Application No: EP/58/21/HH
Site Address: Mistibeech 15 Tamarisk Way East Preston BN16 2TF
Description of works: Erection of part single, part two storey rear extension with roof terrace, garden outbuilding in rear and detached garage to front following the demolition of existing sun room and roof terraces

This council's Planning & Licensing Committee considered this Application at its meeting on Monday, 28th June.

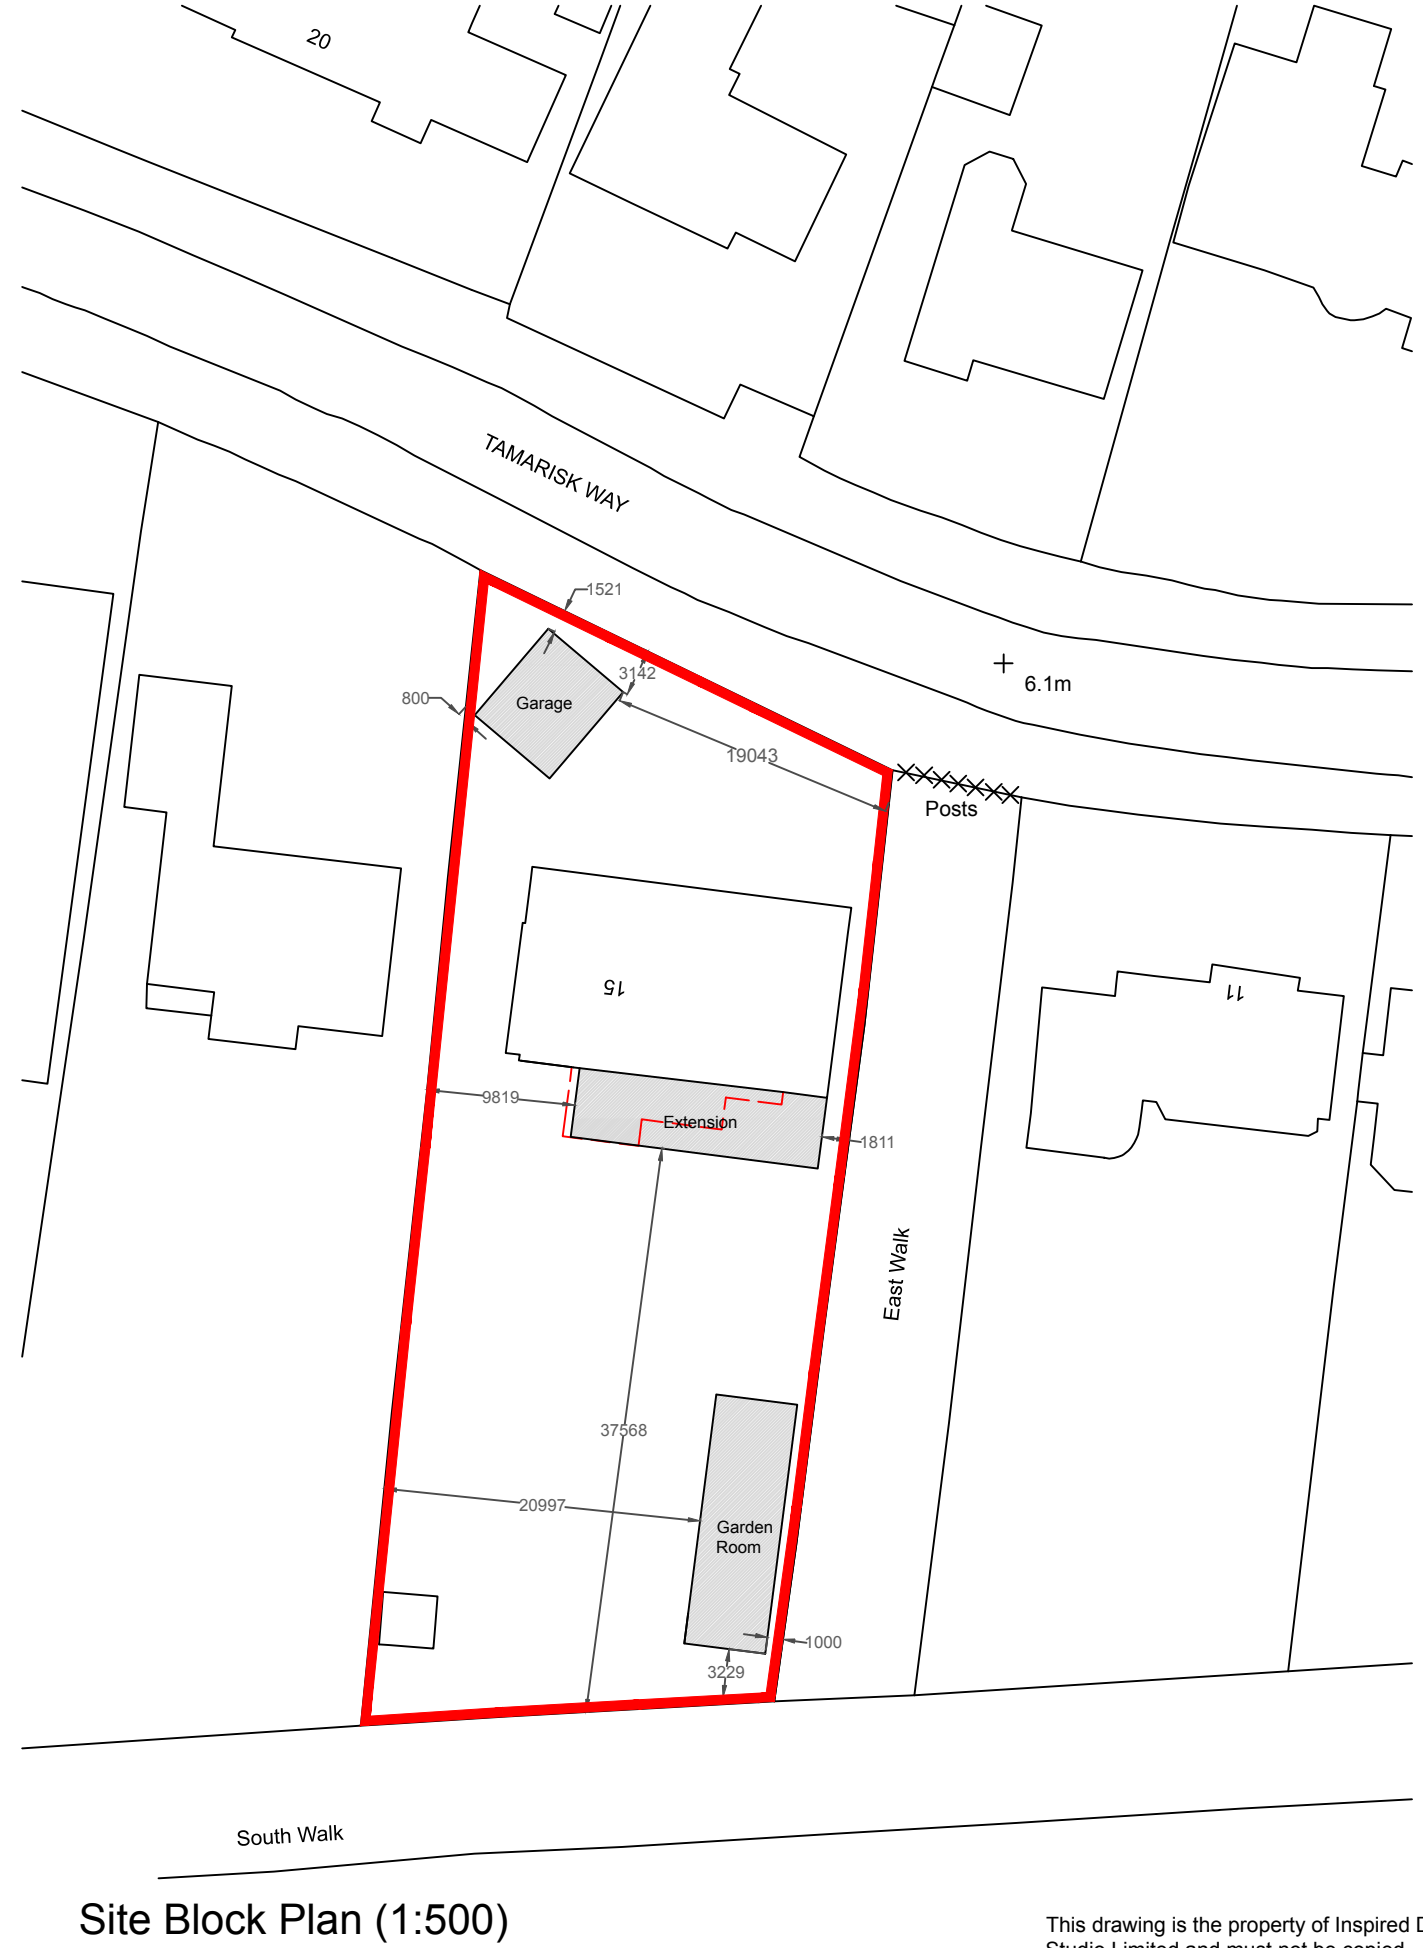
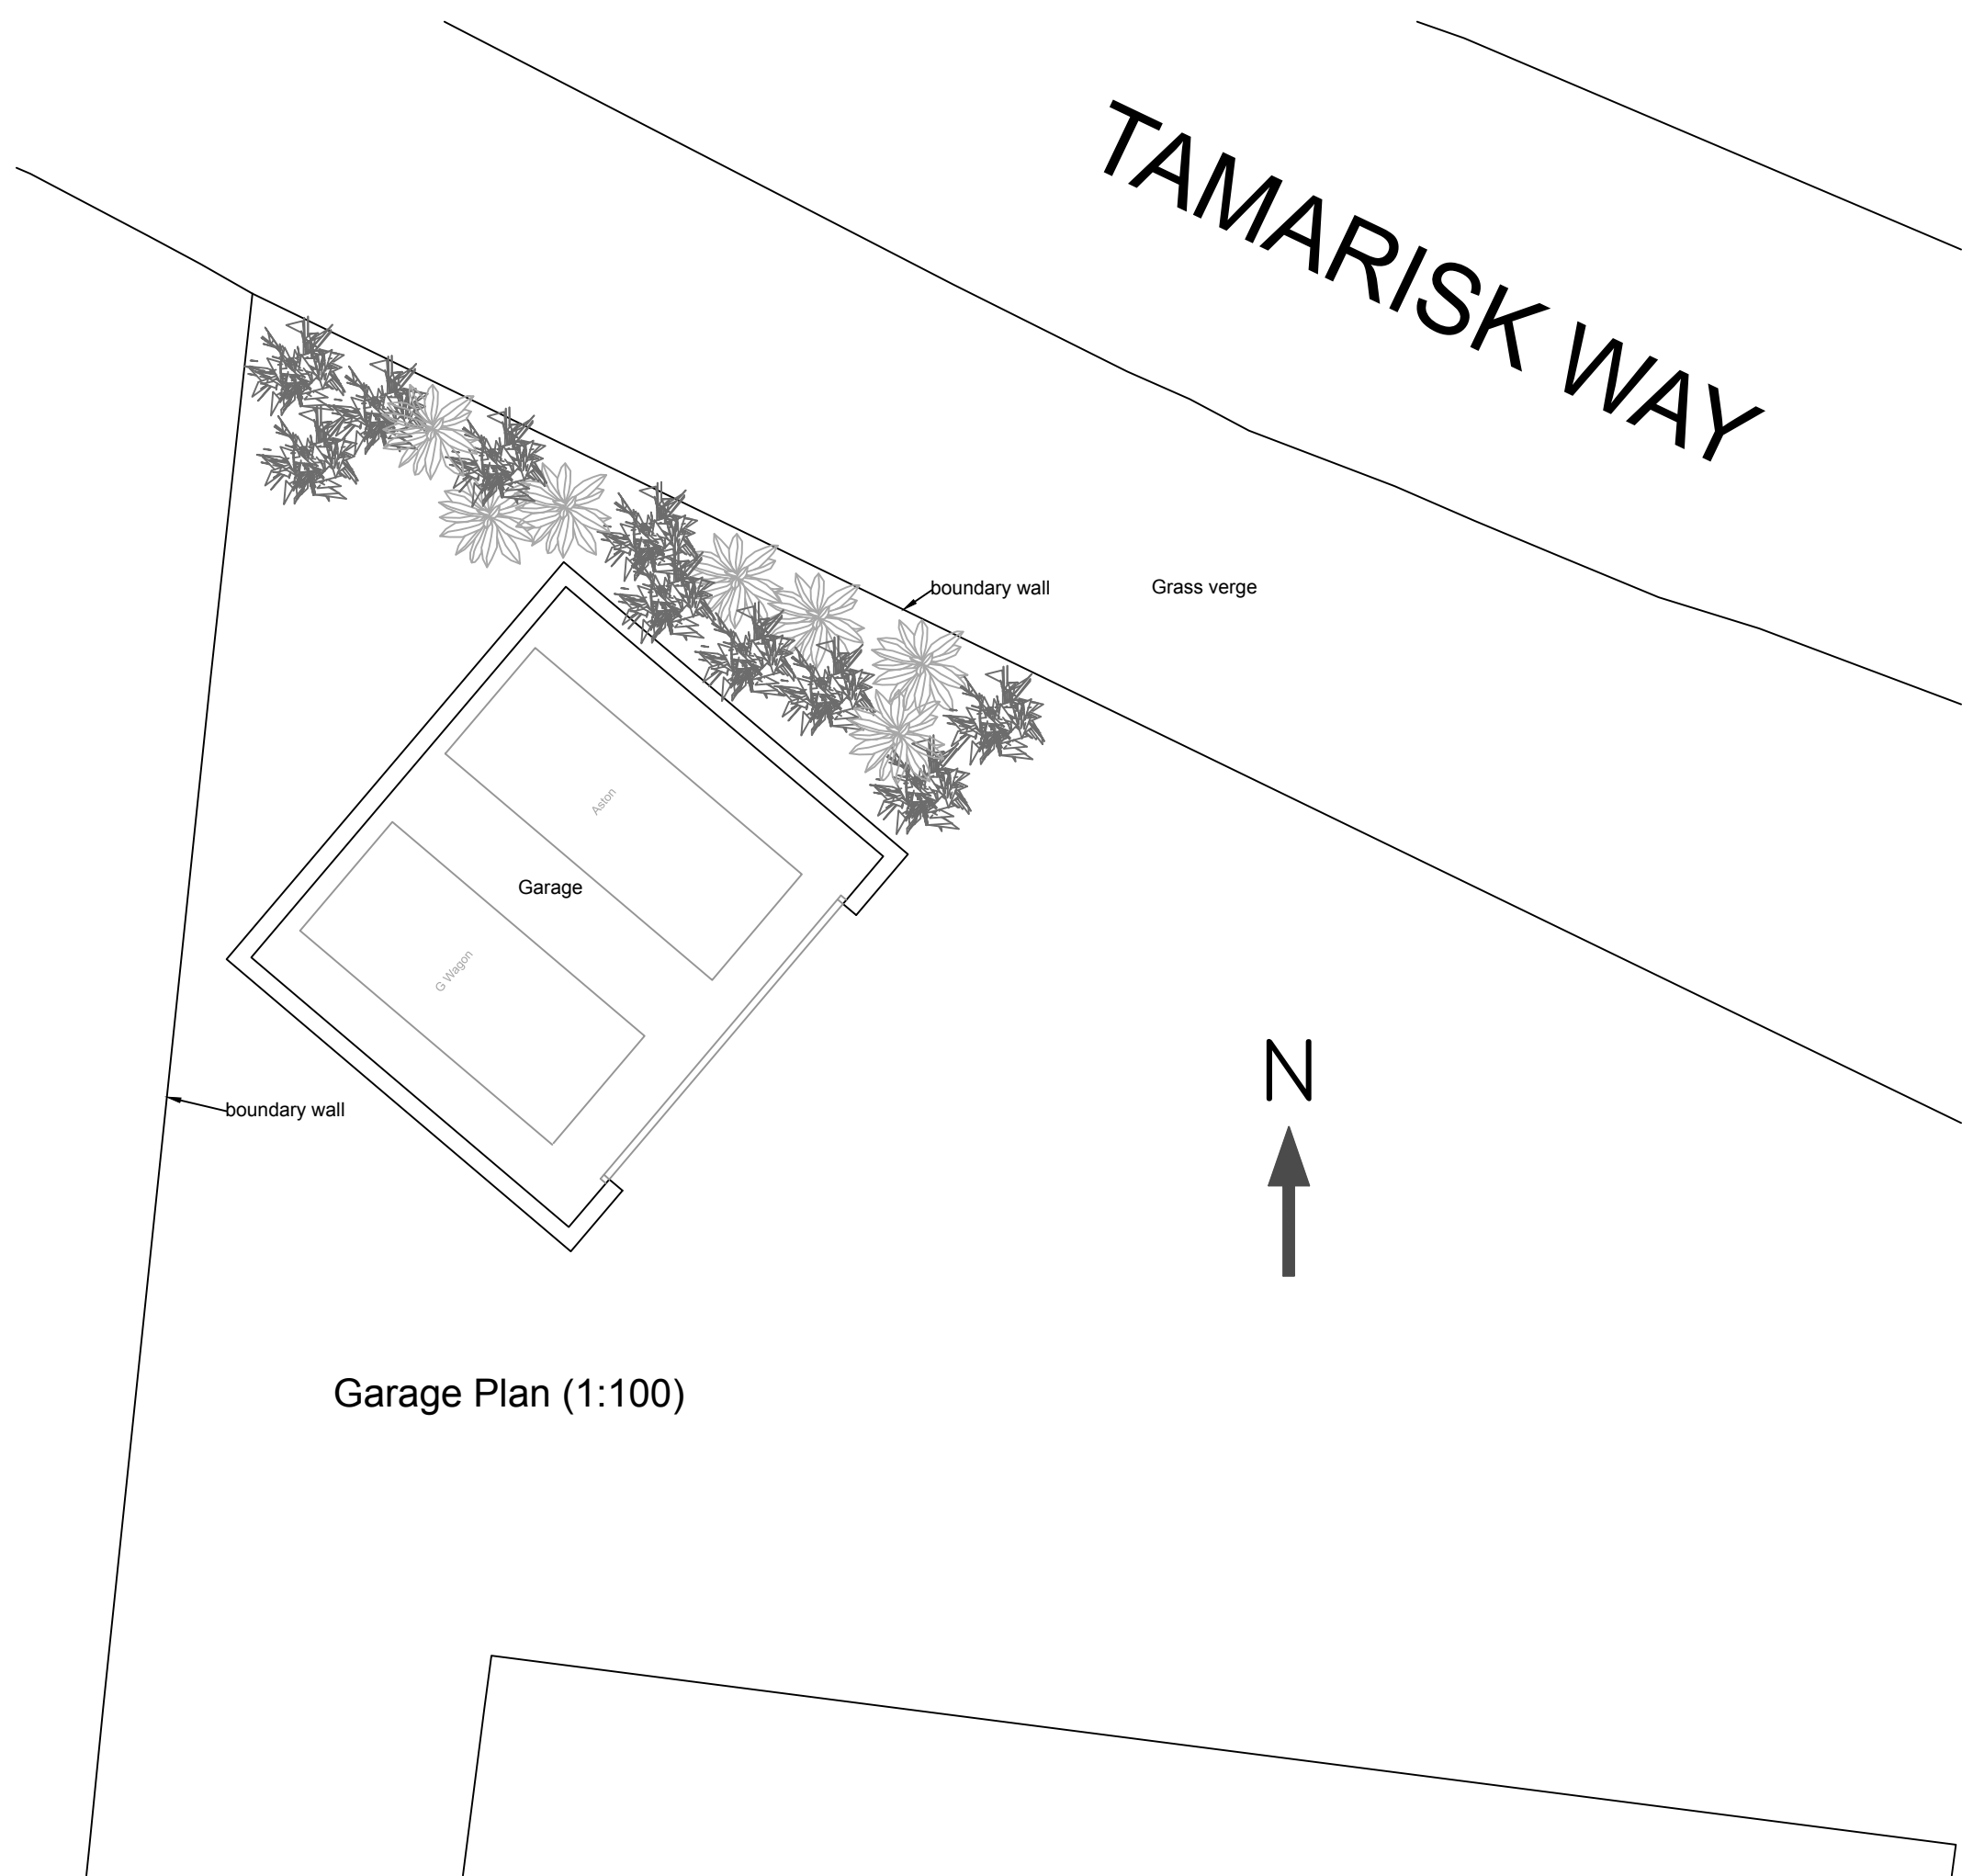
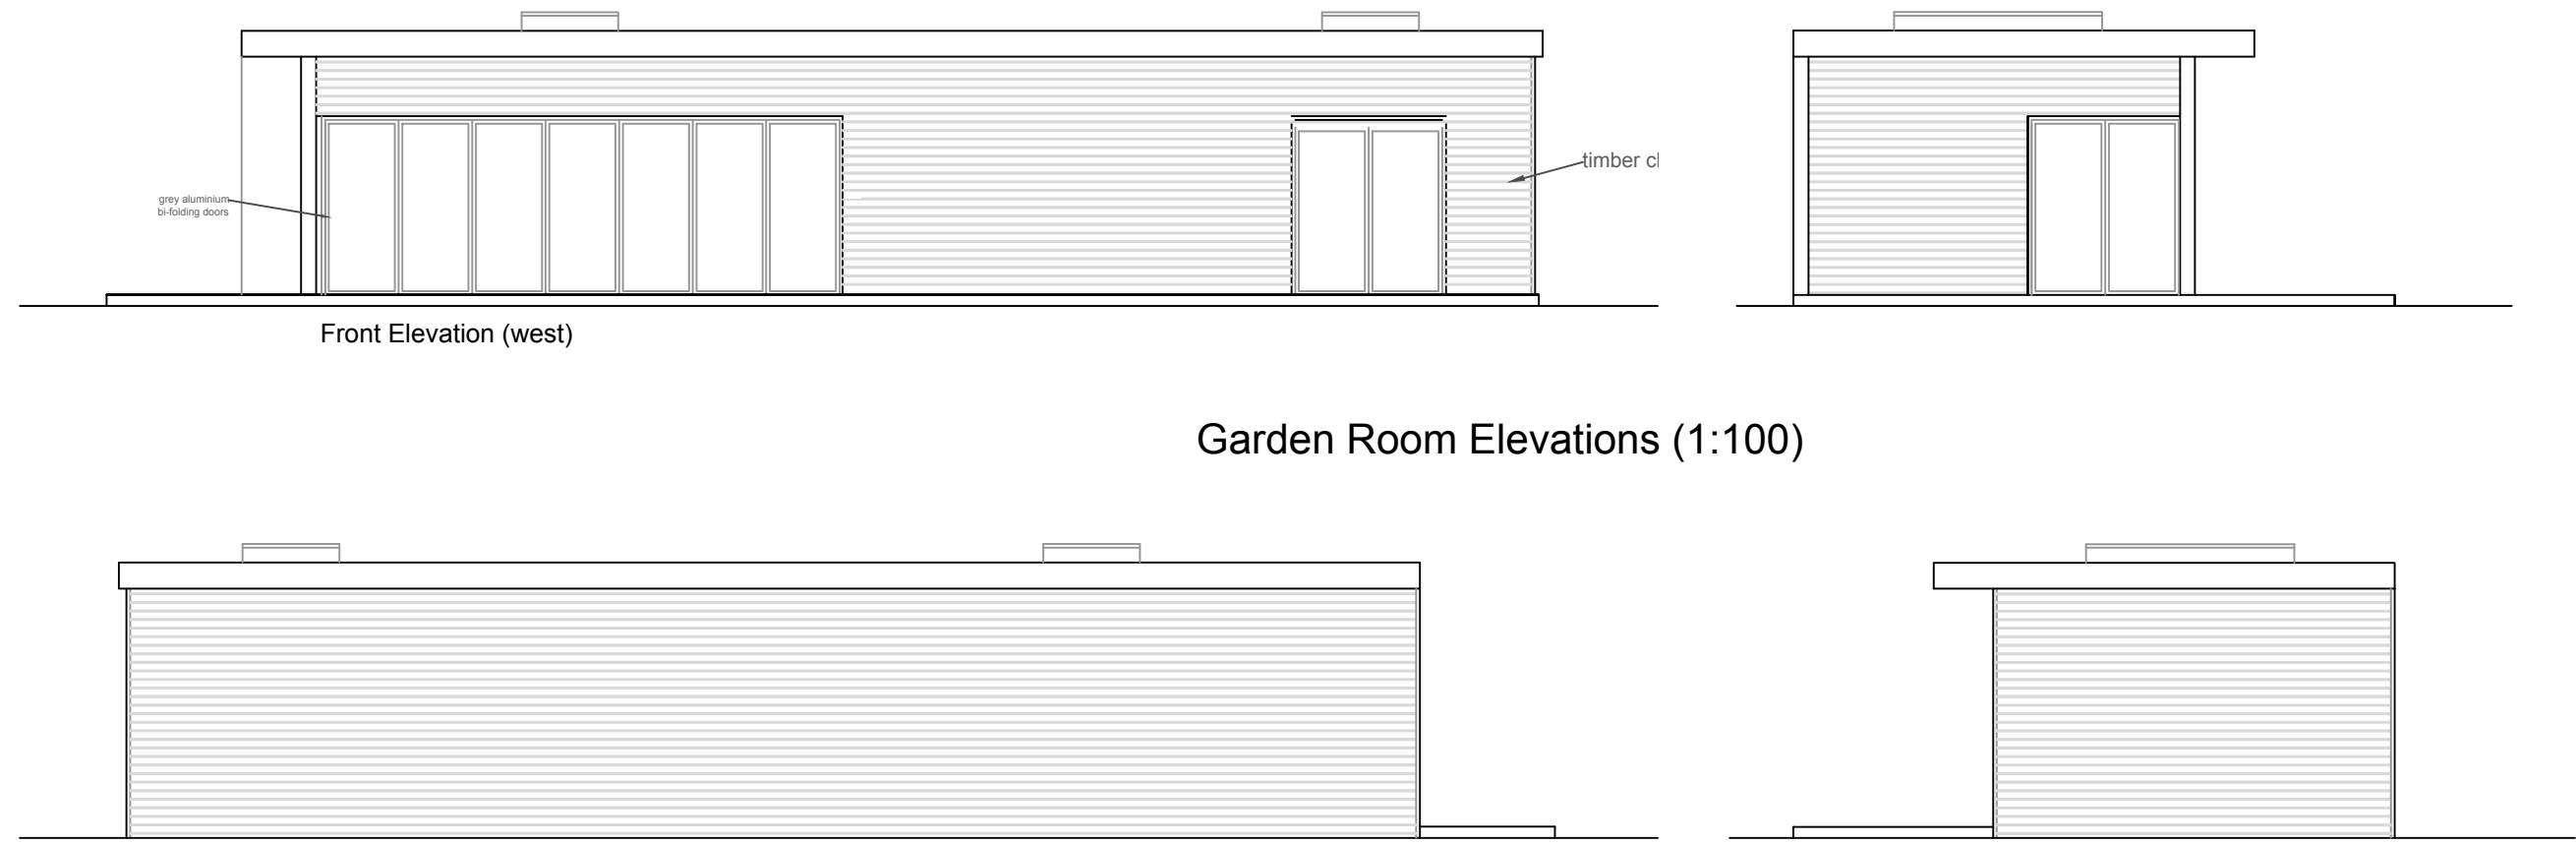
The proposed garage is set too far forward on the plot and would have an unacceptable impact upon the streetscene.

As no proposed North elevation has been provided, the committee has been unable to consider the impact the proposed garage will have upon the look of the building itself. However, the committee felt the proposed garage was likely too far from the existing building to integrate visually with it. We believe this to be in conflict with policies D DM1 and D DM4 of the Arun Local Plan and the East Preston Neighbourhood Plan.
